Application no: H23/1155/02

Description: Proposed two storey extension and double garage

Location: Holly Tree House
Malten Lane
Whaplode

Amendment: Omit two-storey southern extension
Dwg.Nos. 1759.02.3A & 1759.02.4A

Date: SEPT
Drawing No: 1750 02 2
Scale: 1:50
A

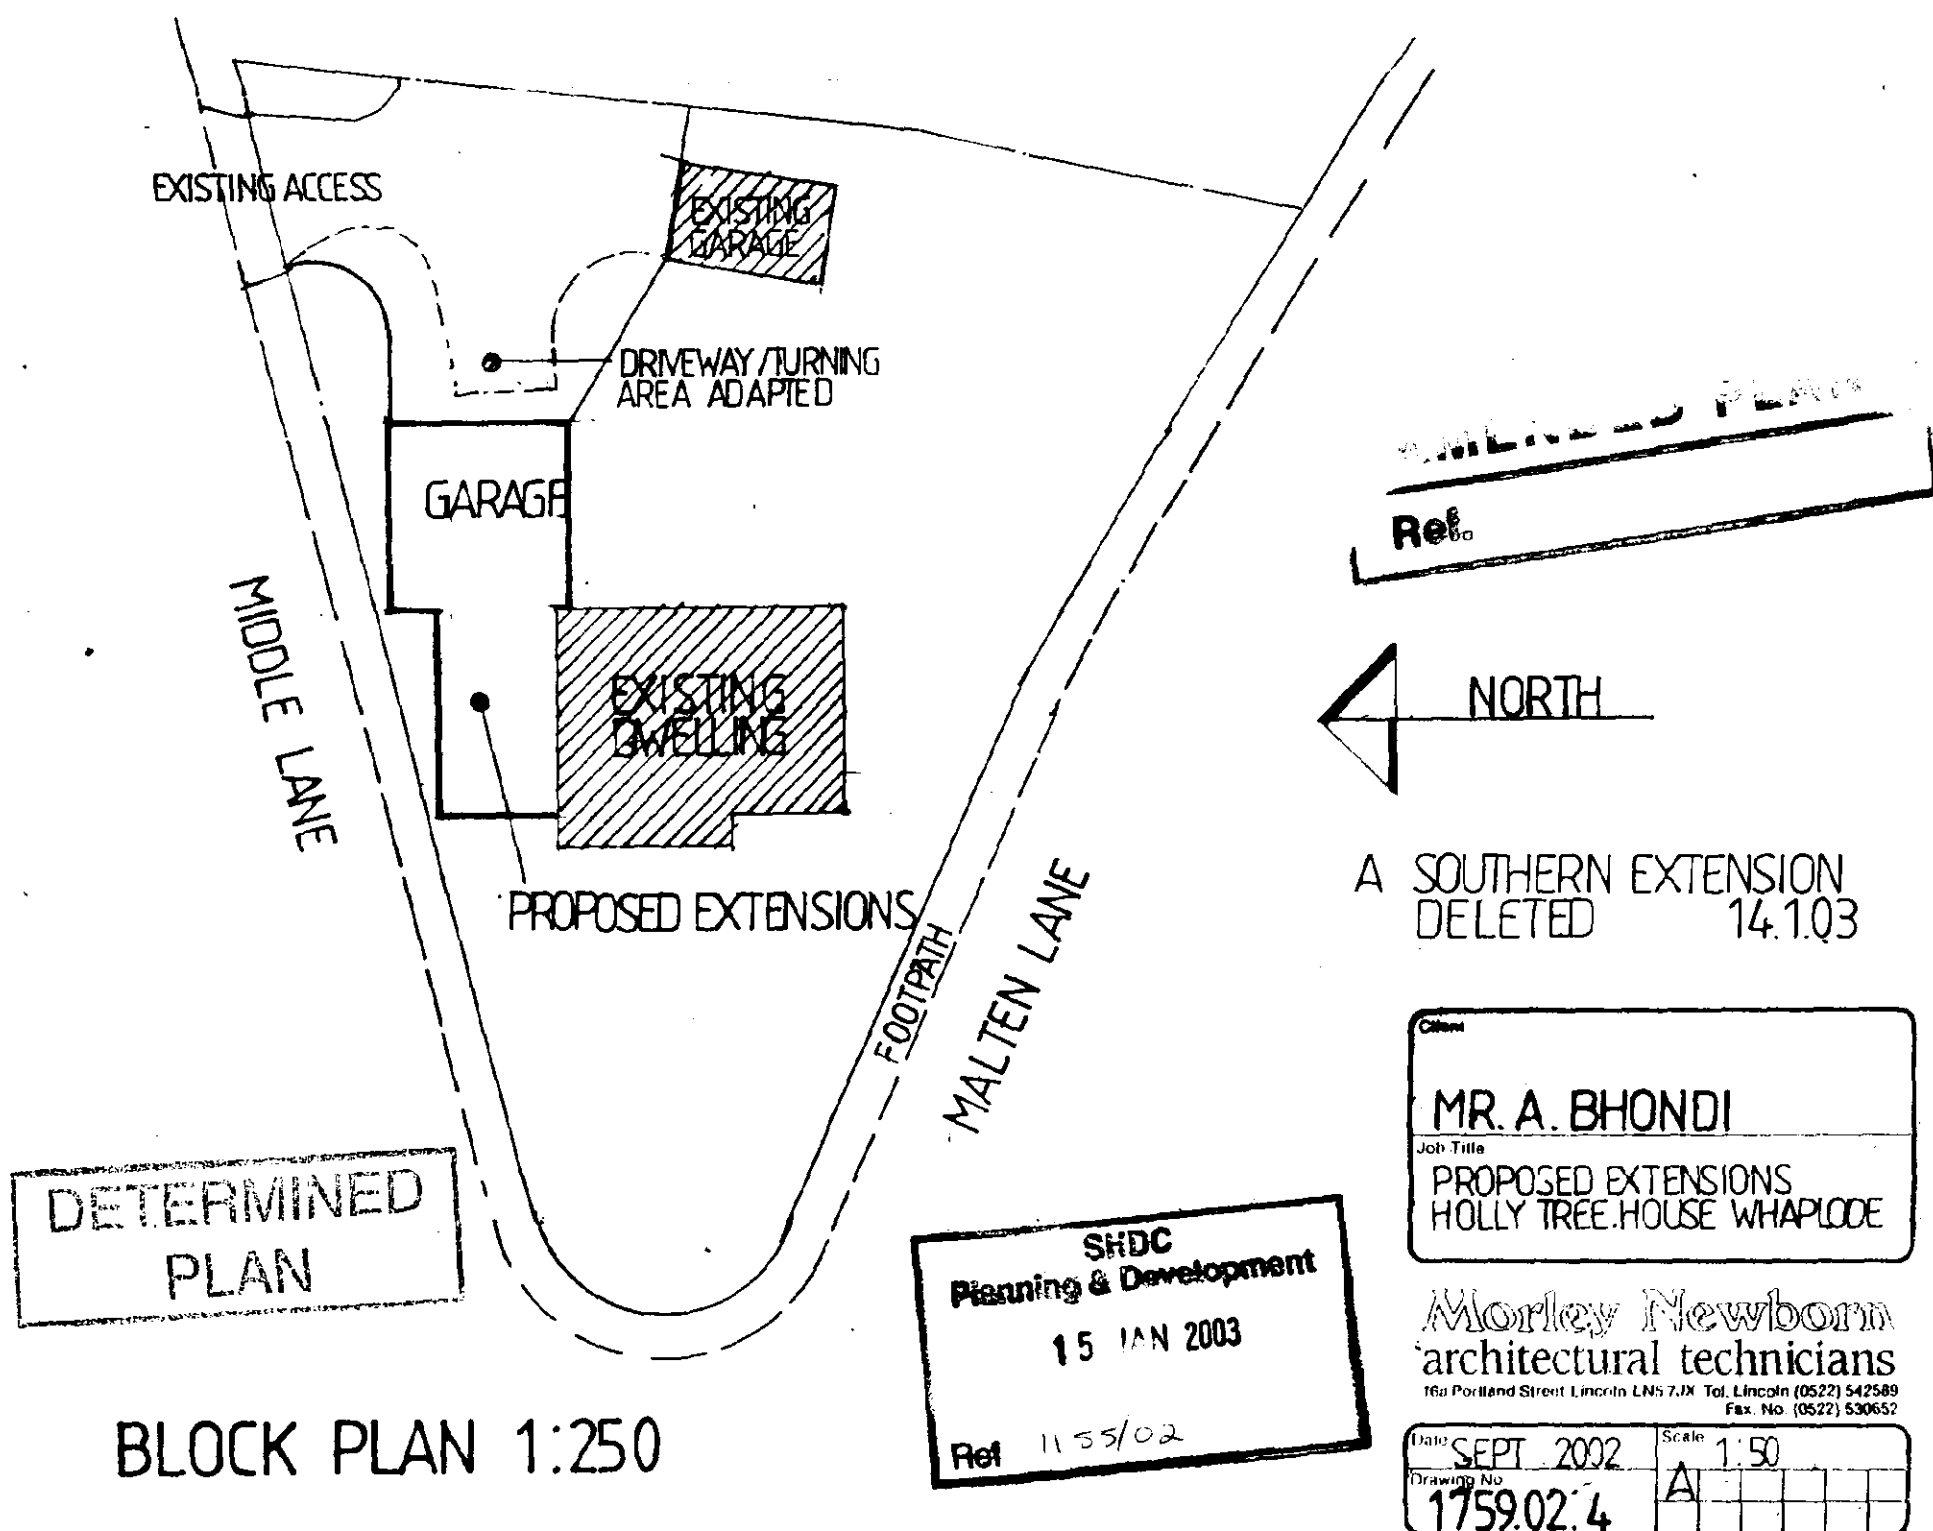
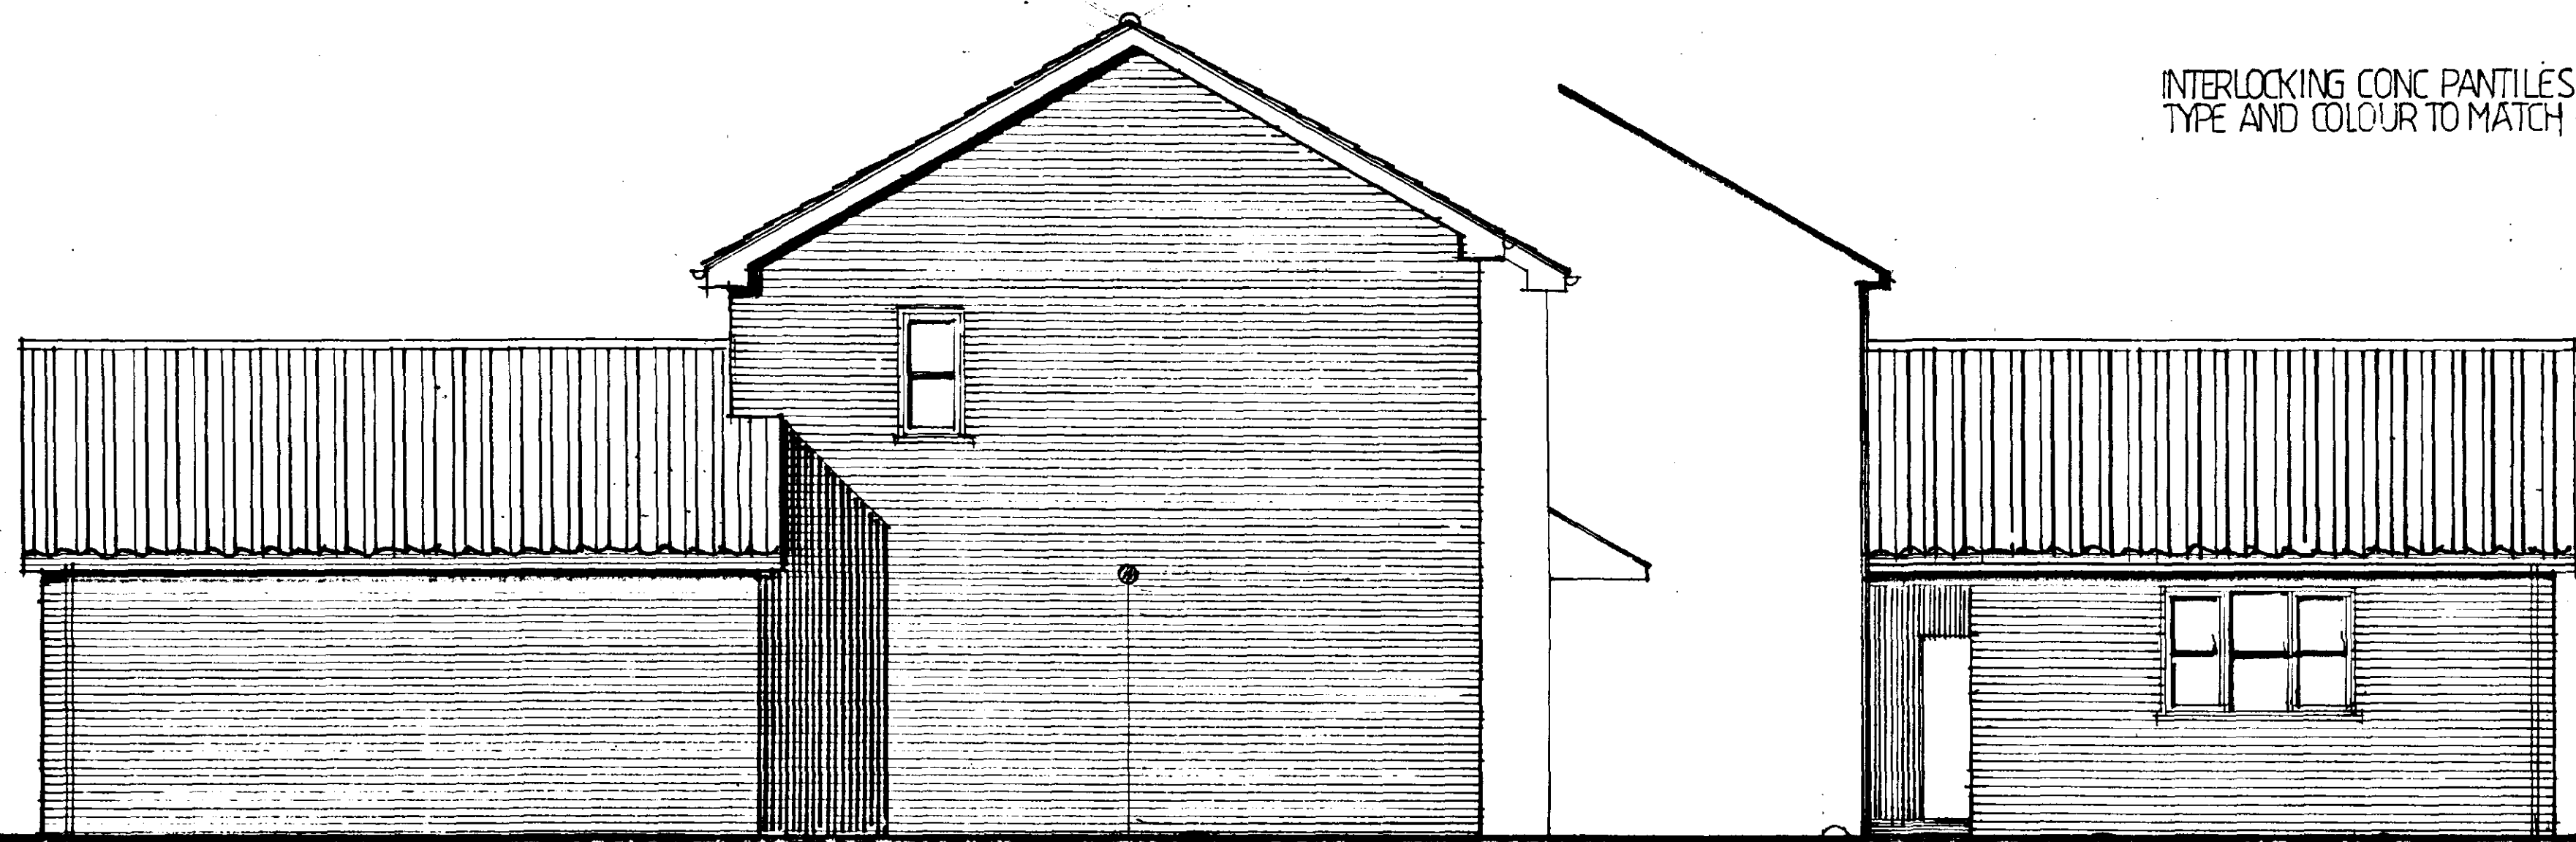
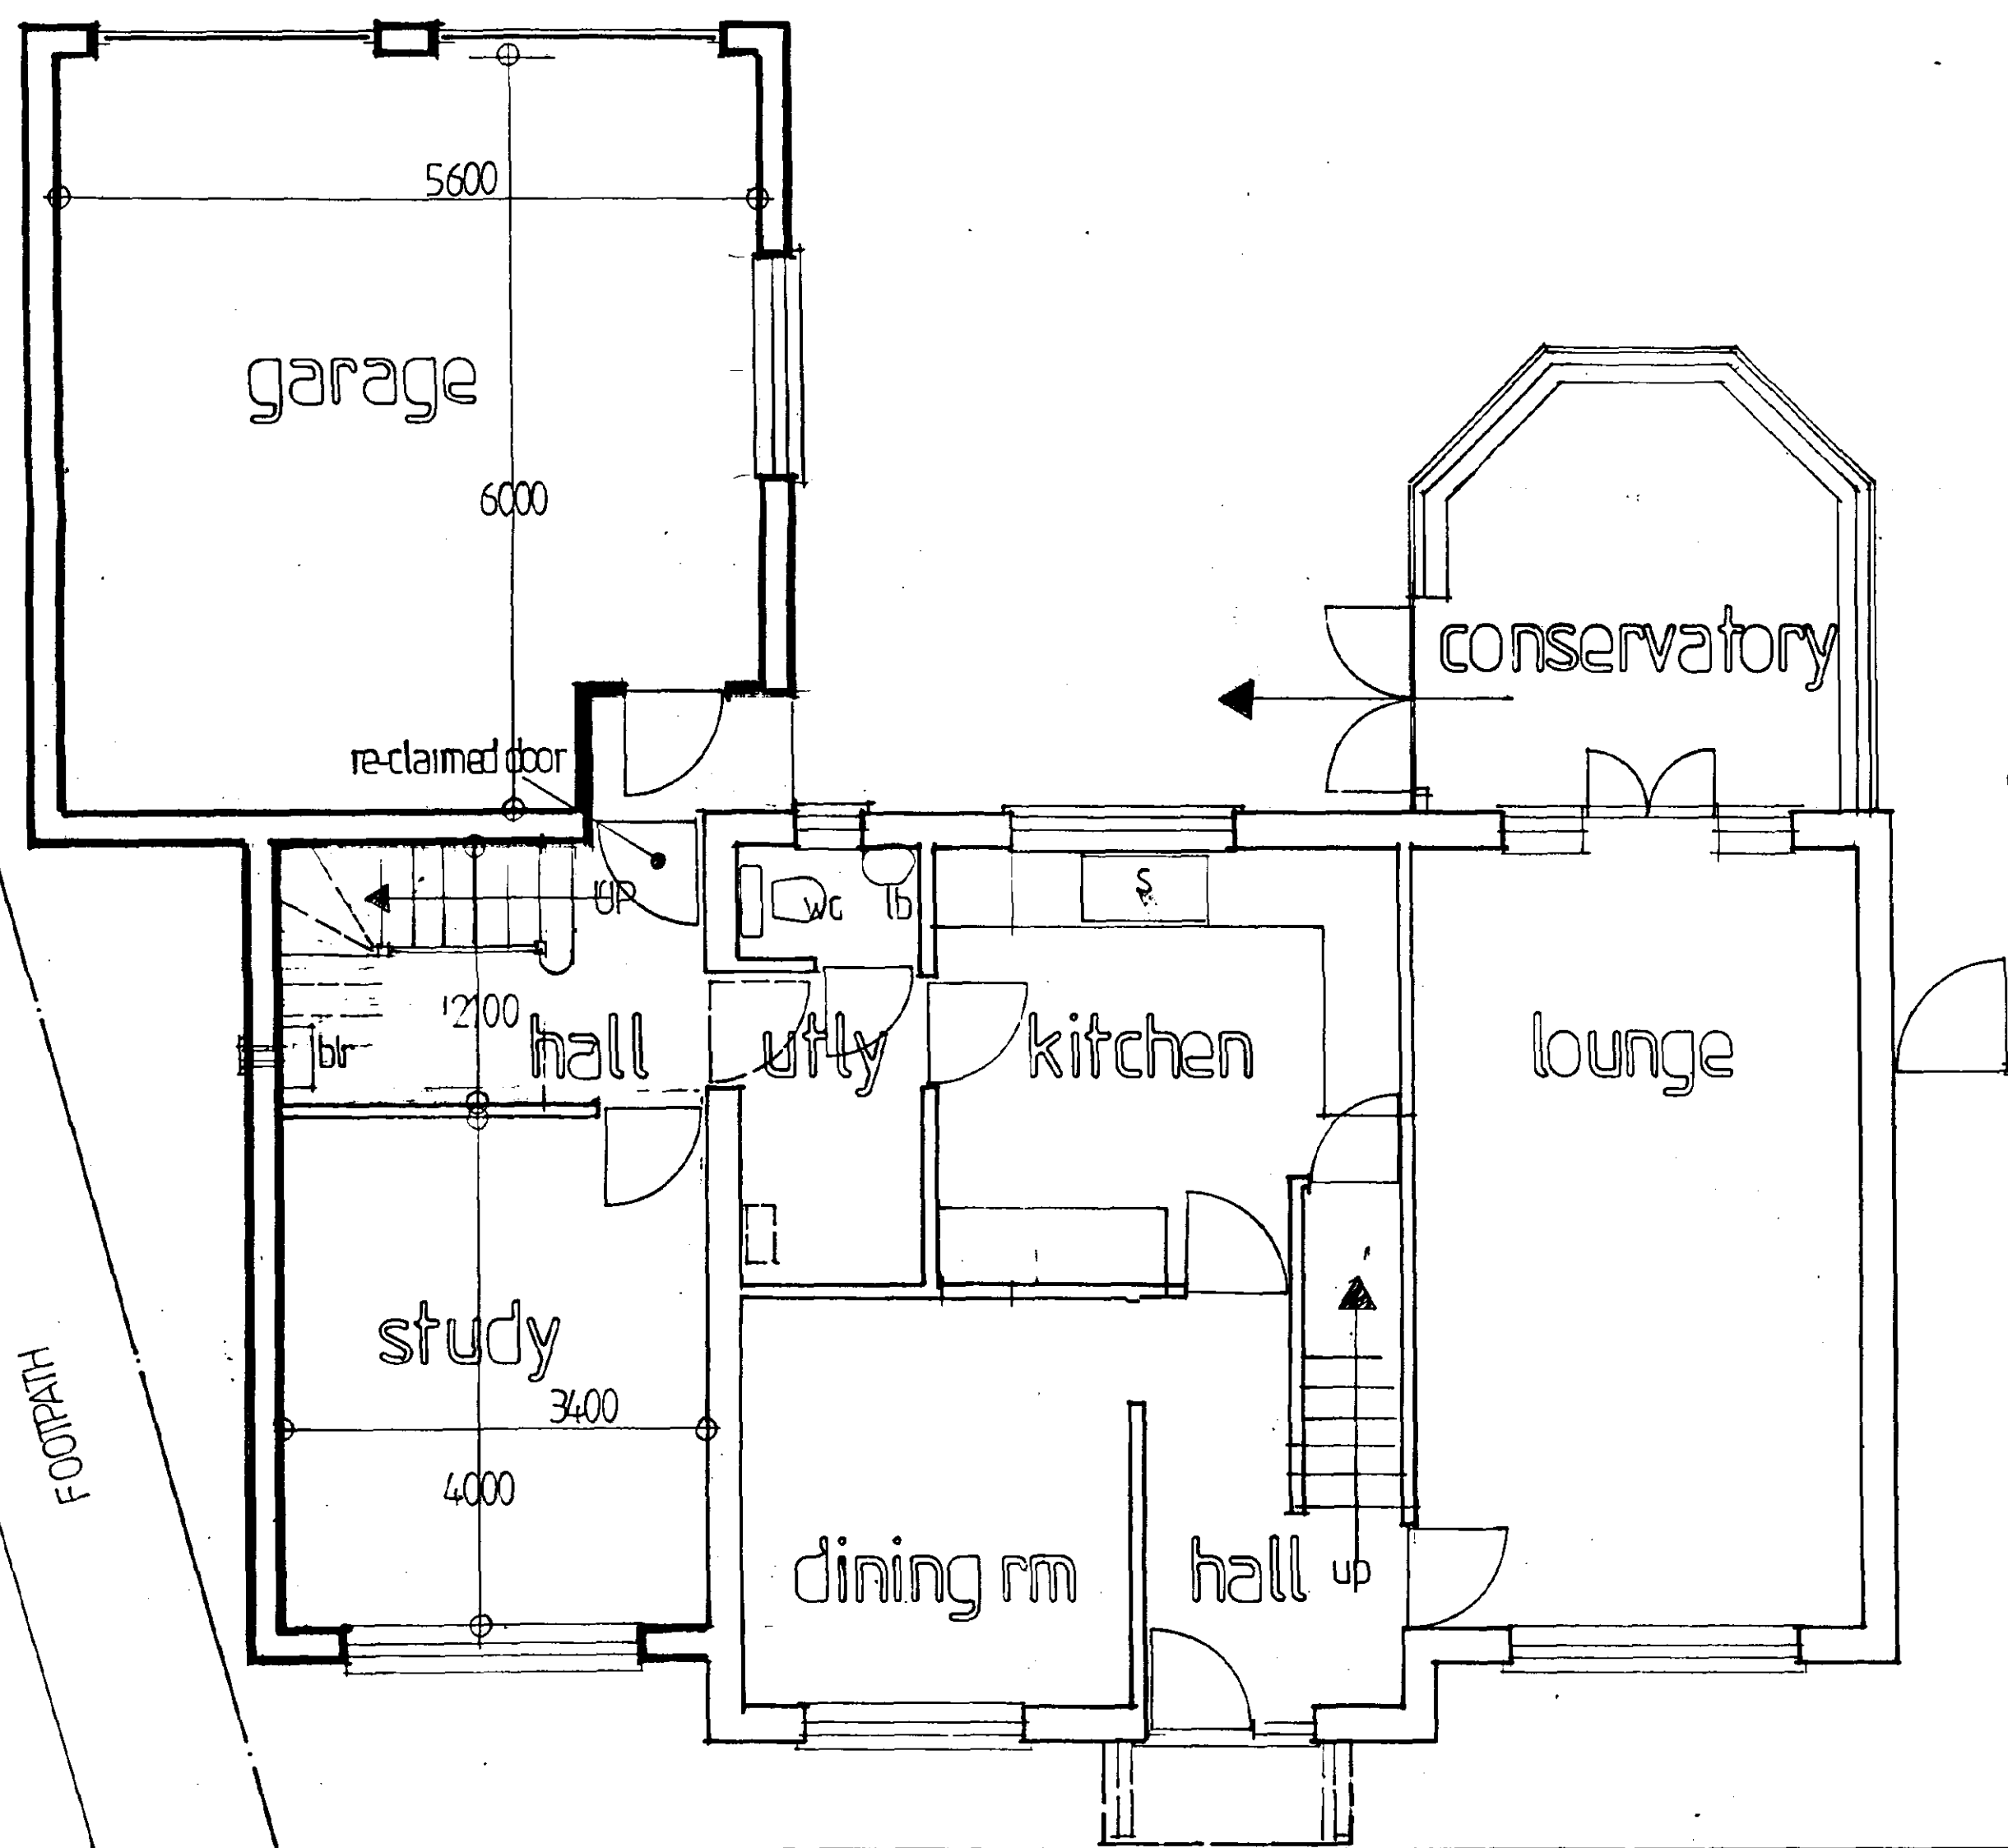
Further to our Planning Application and subsequent telephone conversation with your Mr. Gedney regarding the above, we have discussed the application with our client, Mr. Bhondi and he has decided to omit the two storey southern extension completely.

Please find enclosed two copies each of drawings number 1759/02/3A and 4A showing the proposed revisions for your consideration.

Amended plans have now been received which omit the extension on the southern side of the building. Also, the only window now proposed on the rear elevation at first floor level is associated with an ensuite and will therefore be obscure.
